**Stephane Kerr**

15 October 2020

**SSD-7539 Darlington Terraces Mixed Use Development  
University of Sydney 4<sup>th</sup> Response to Submissions**

DA3905

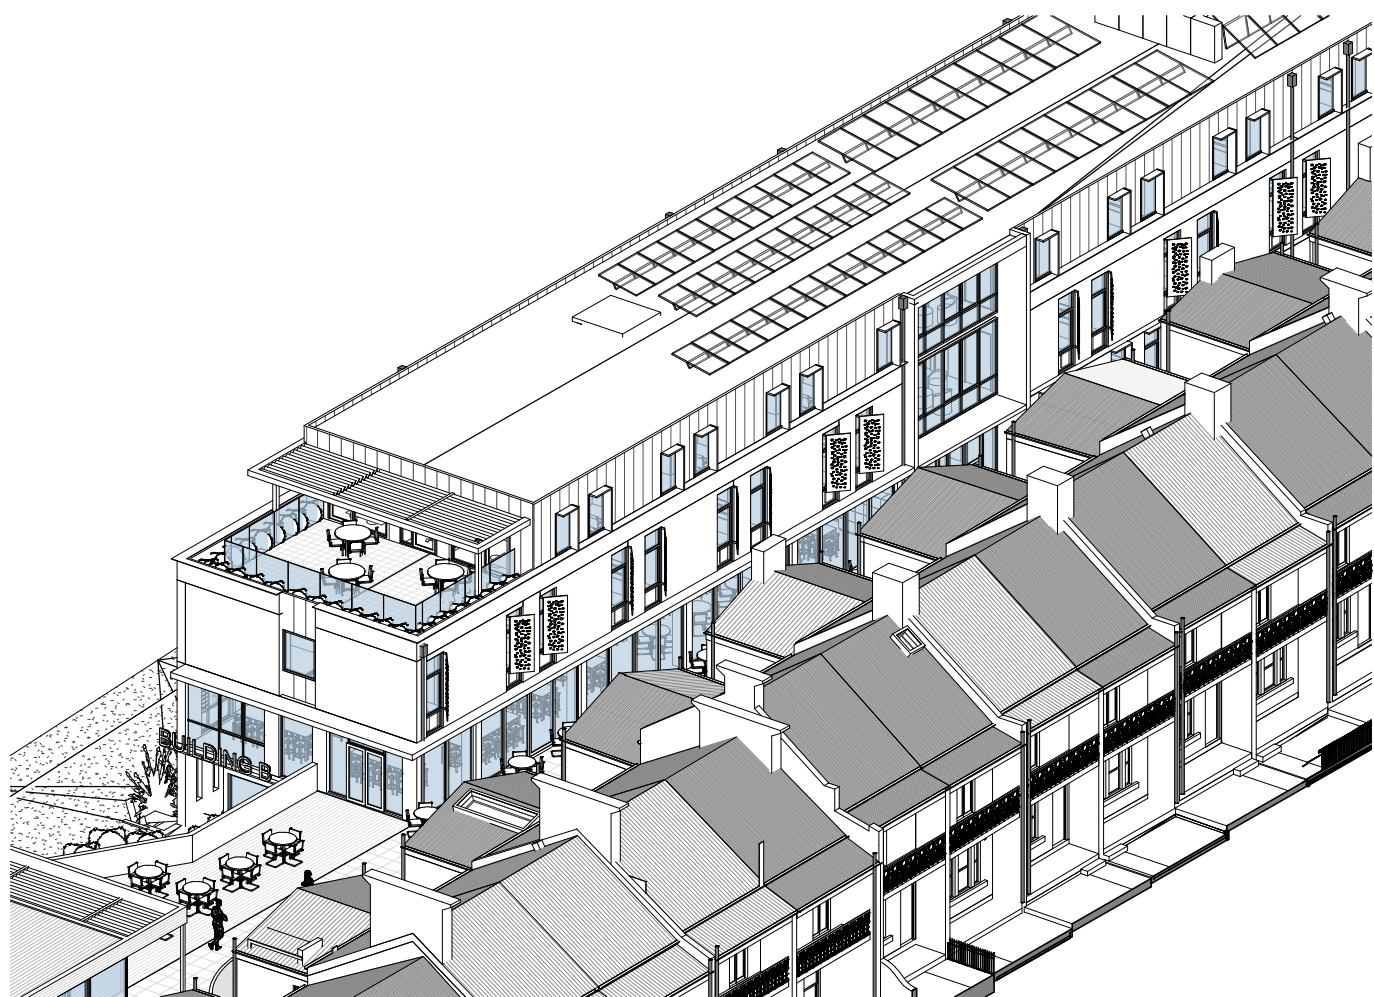
**DPIE Issue 1:** Request for a set of amended plans that includes all plans where amendments affect the drawing, including affected elevations and shadow diagrams (3901-3903 and 3905).

**University response:** The University submits an updated set of amended plans reflecting all current proposed plans, elevations, and shadow diagrams. Please refer to following Attachments accompanying this submission:
